FERRING CRICKET CLUB

2nd June 2018

Dear Mr Crowther 32 & 34A Sea Lane Ferring - FG/174/17/PL

DRAWING TITLE
Proposed Site Plan, Location Plan
and elevation from south

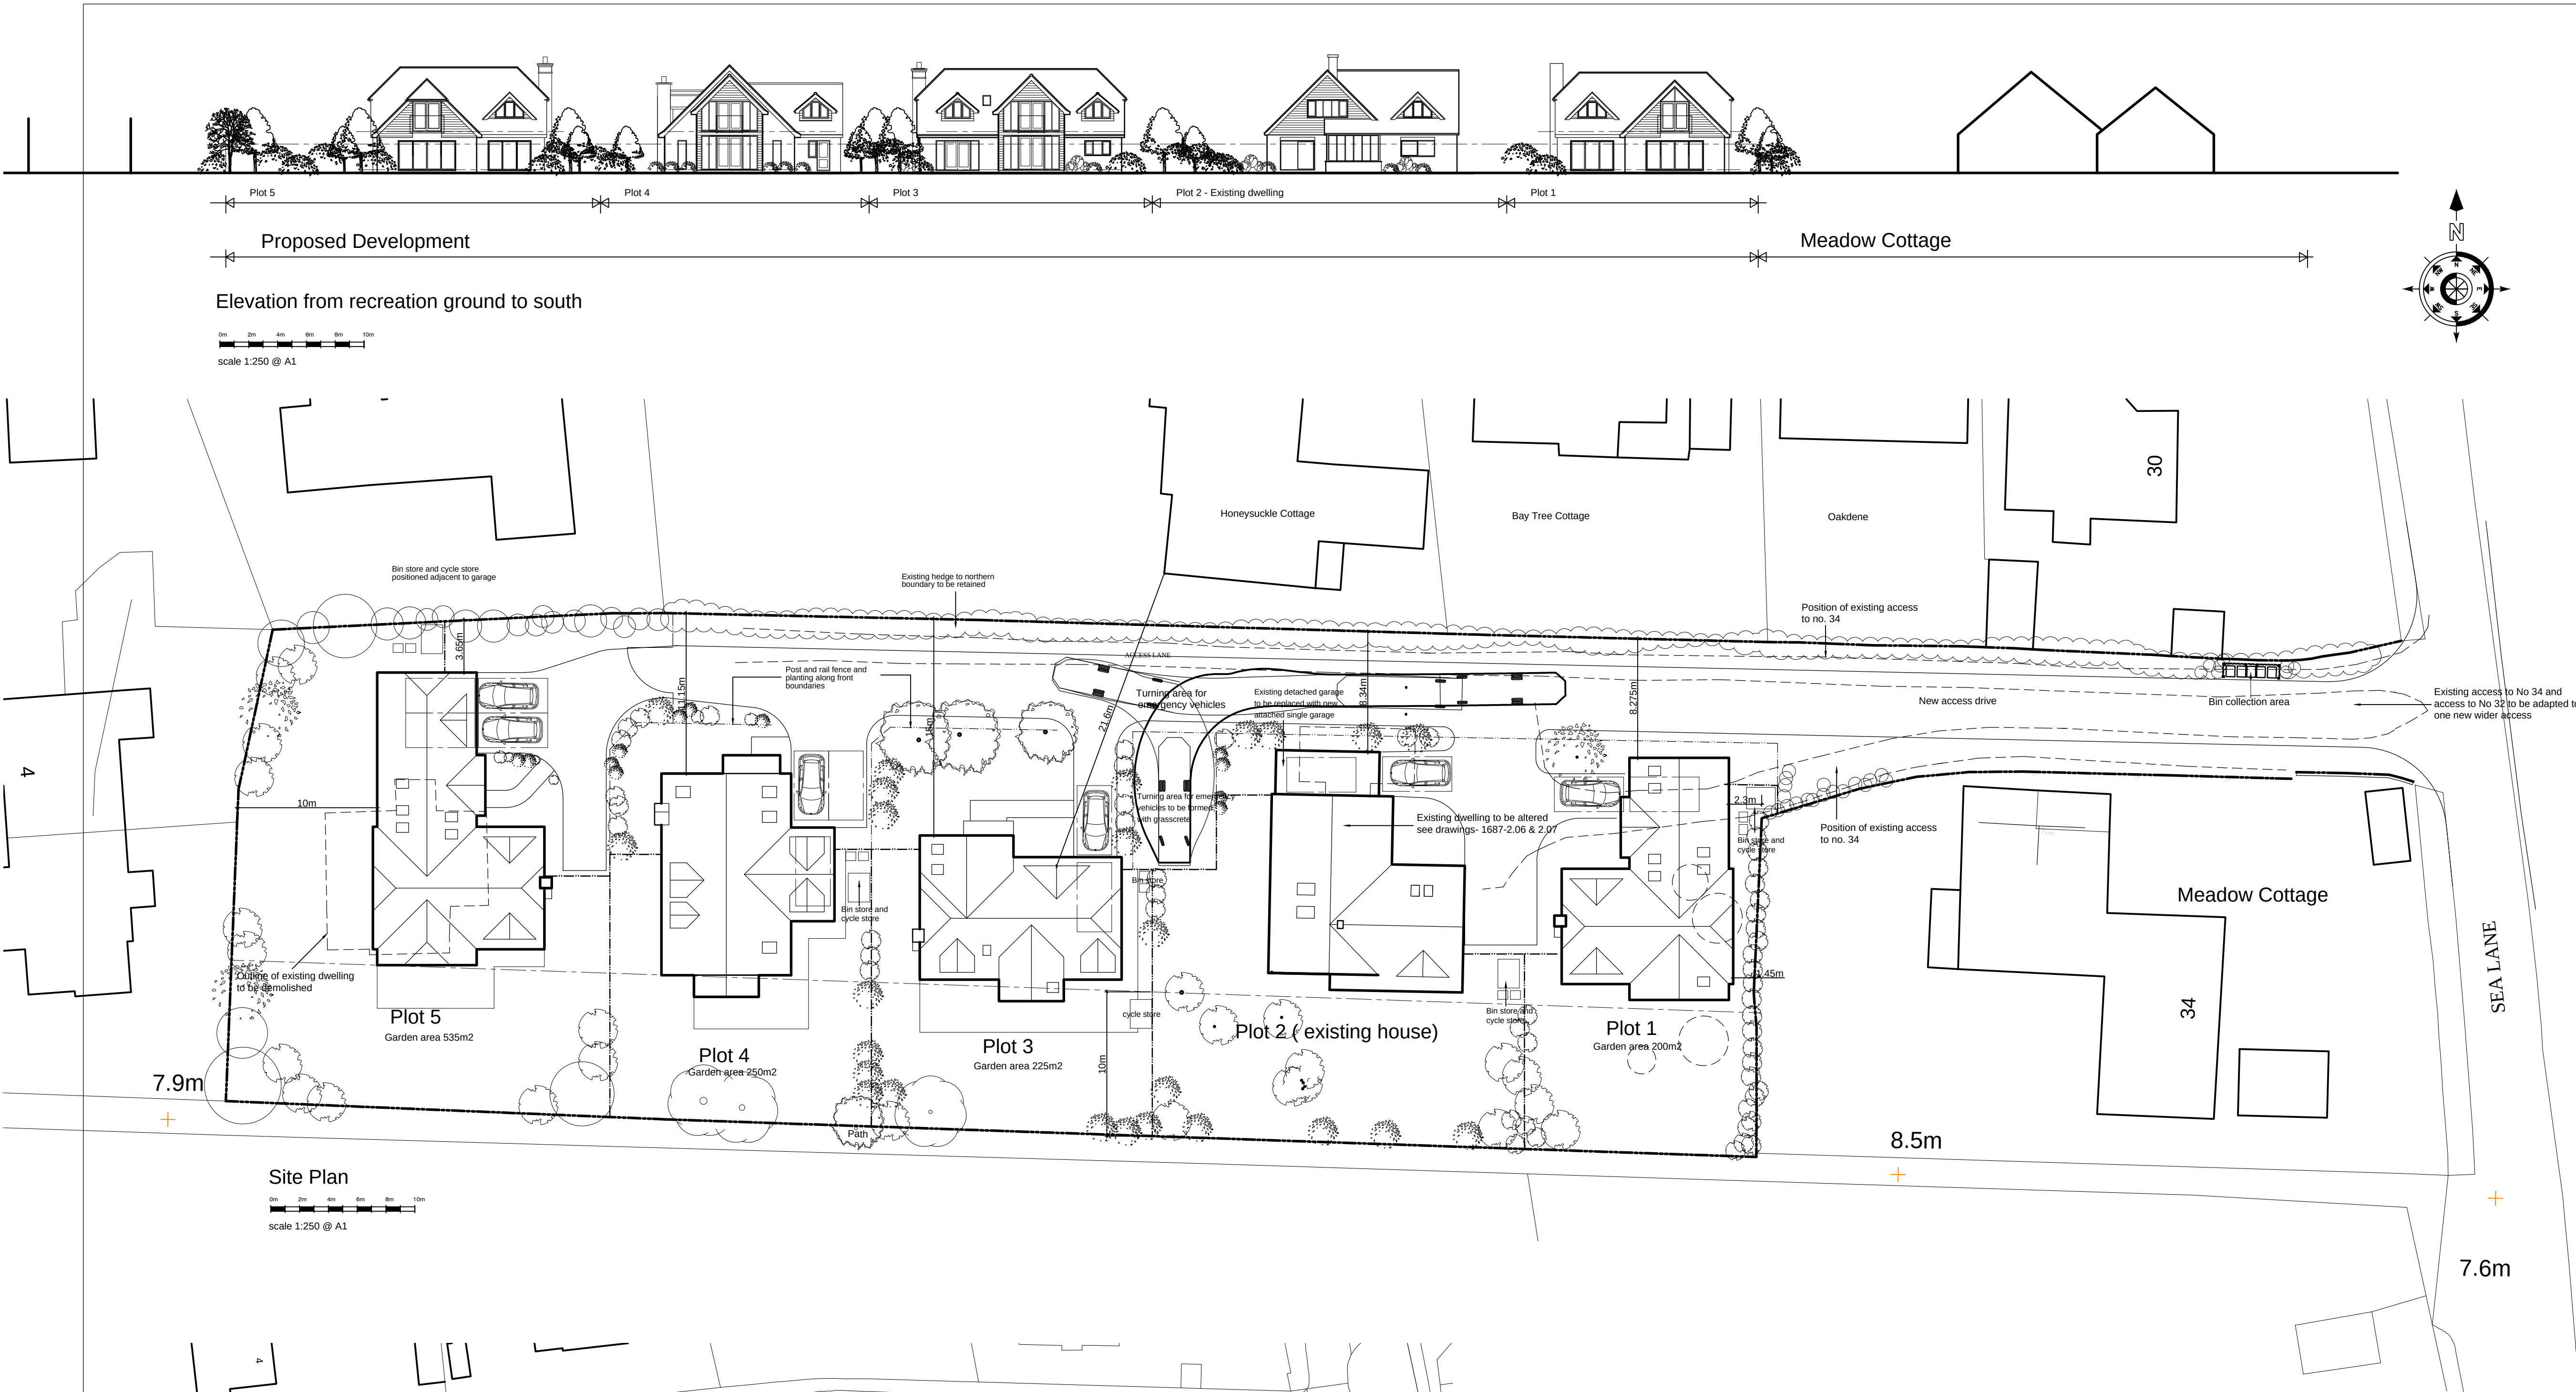
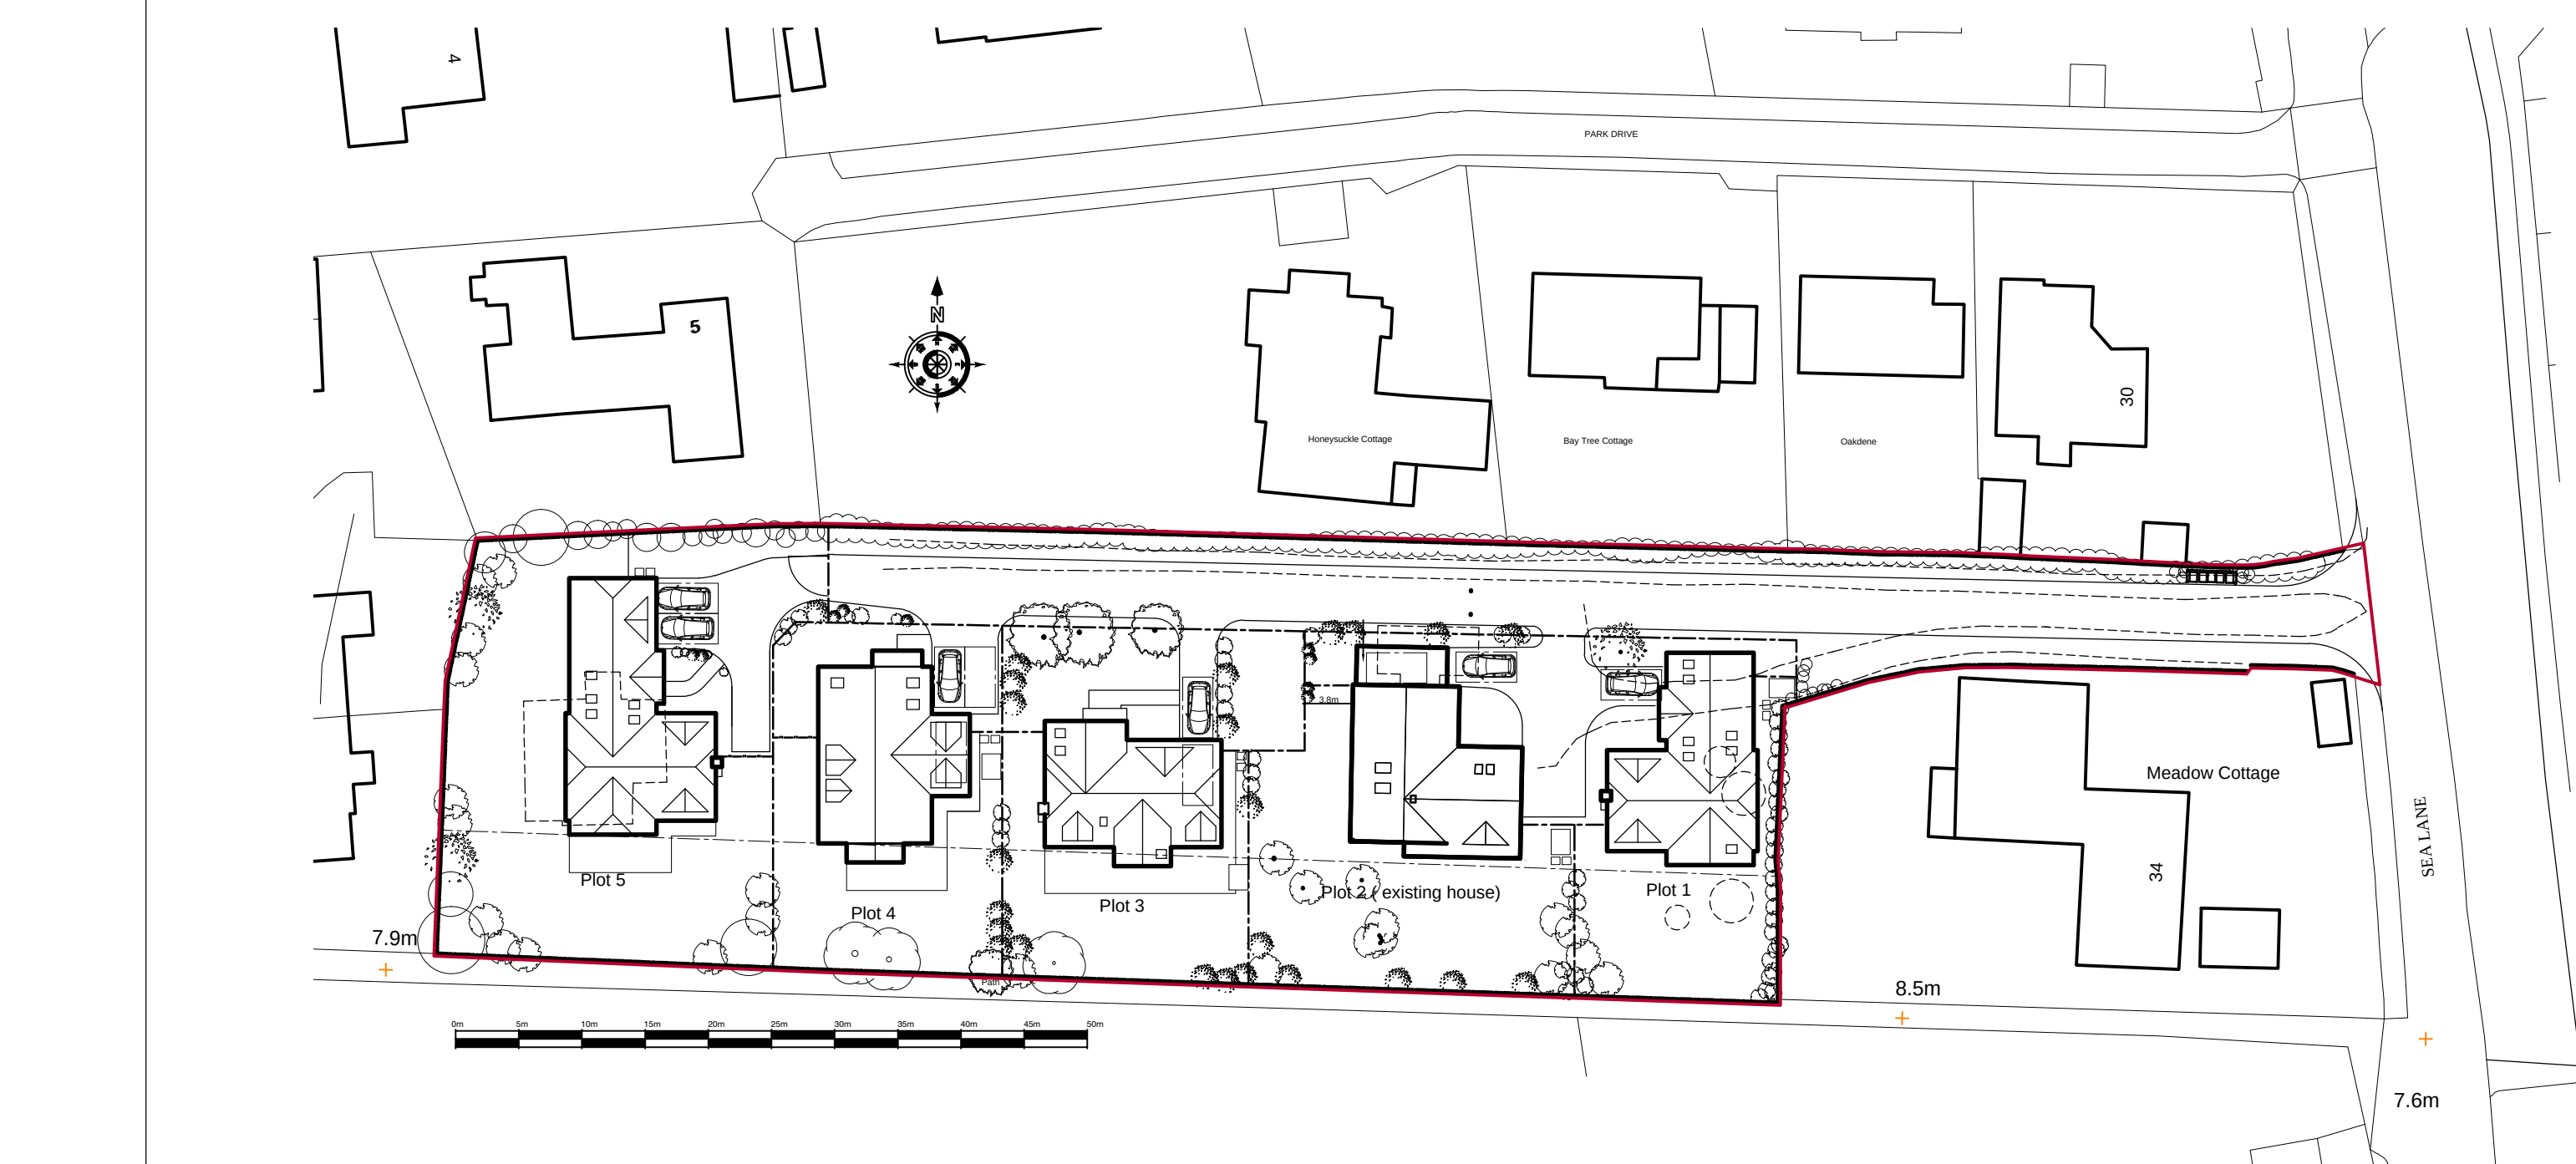
We note that the existing 1.8m high fence is considered adequate mitigation to significantly reduce the frequency of cricket balls oversailing the fence, though insufficient to stop all shots.

The report stated that by extending the height of protection to 3m, a higher reduction of risk was available.

This technical report by Labosport went on to recommend their client (Designer Homes LLP) discuss the plan with the ECB and / or Sport England along with our club to ensure whatever system is proposed is suitable in mitigating the risk and practicable for the club's use.

Given the recent serious injury to a 5 year old boy in Poole when hit in the face by a cricket ball oversailing the school boundary protection we would have preferred this discussion to have taken place.
